OXFORDSHIRE COUNTY COUNCIL'S RESPONSE TO CONSULTATION ON THE FOLLOWING DEVELOPMENT PROPOSAL

Application no: 23/01493/REM

Proposal: Reserved Matters Application including access, layout, landscaping and scale pursuant to outline planning permission 14/02121/OUT for internal primary and secondary streets along with the partial discharge of conditions 12 (Building for Life 12), 16 (means of vehicular access), 17 (means of pedestrian/cycle links) and 19 (detailed surface water drainage scheme) for Phase 1B

Transport Schedule

TITLE
**S278 OFFSITE HIGHWAY WORKS
PRIMARY ACCESS JUNCTION
GENERAL ARRANGEMENT
SHEET 1**

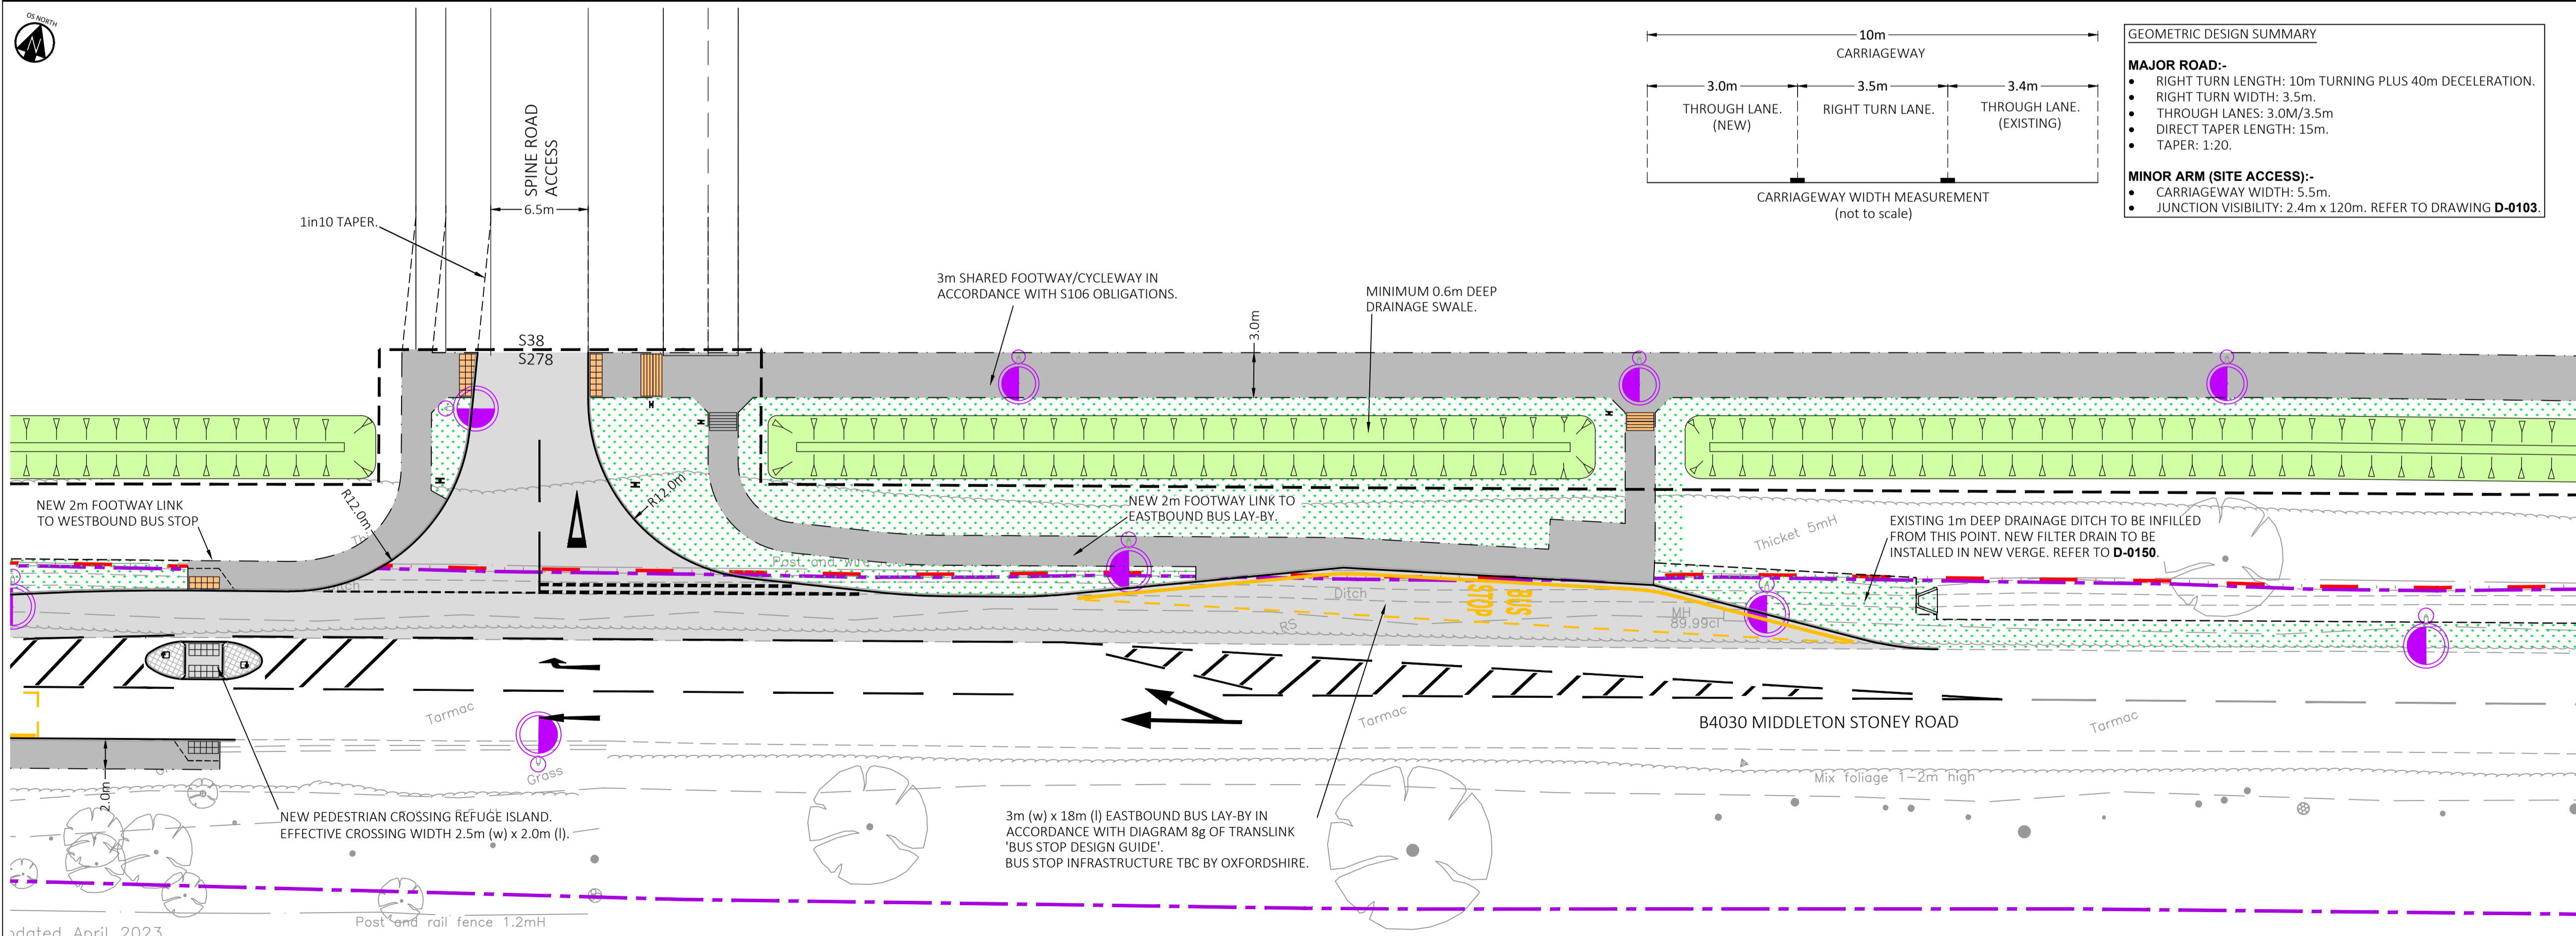
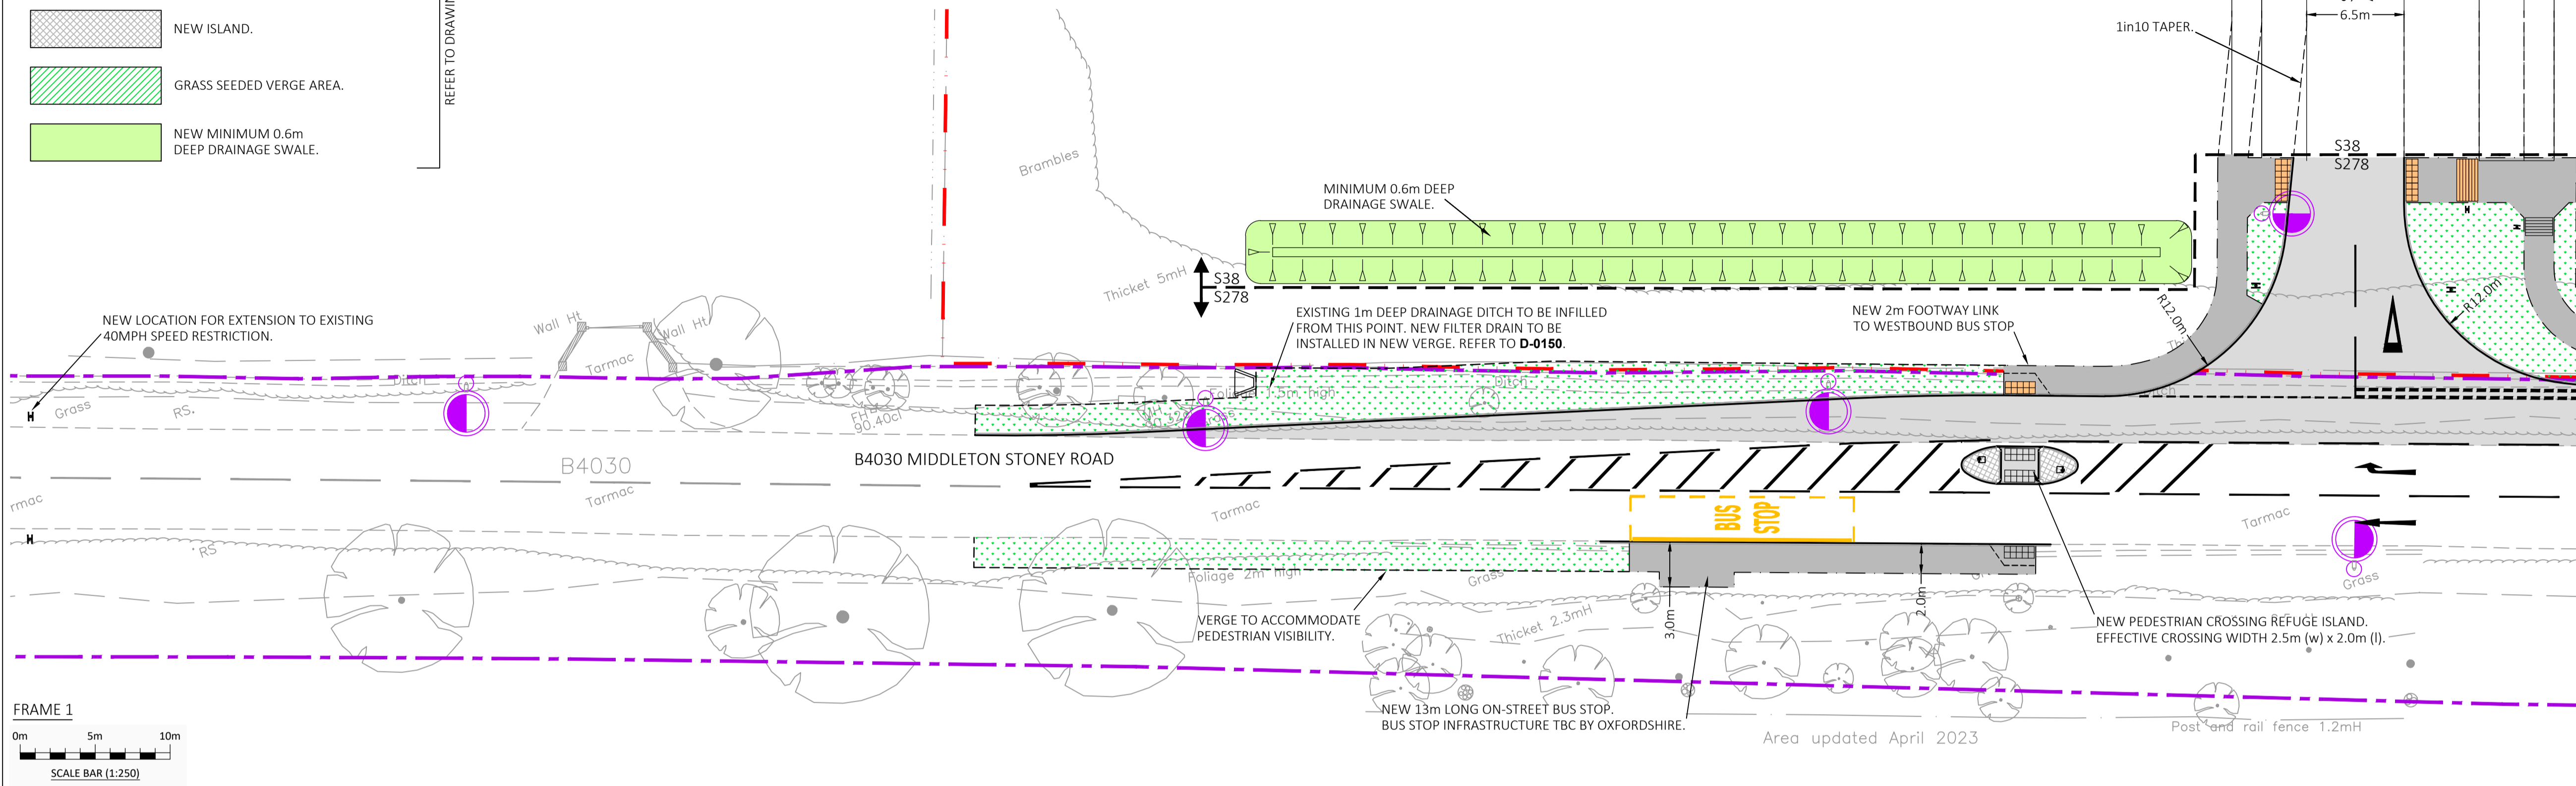
Cycle track along southern boundary: See comments in response to consultation on masterplan for 'other uses' area. Also, the crossing at the Secondary Street needs to be LTN 1/20 compliant. Priority should be given to cyclists and pedestrians across the access road.

Where the cycle track cuts through the hedge, the alignment should be more of a lazy S rather than 90 degree bend, for safety reasons. A verge buffer should be provided between track and kerb.

Width of this track is not clear - Design Code says 4m wide - please clarify.
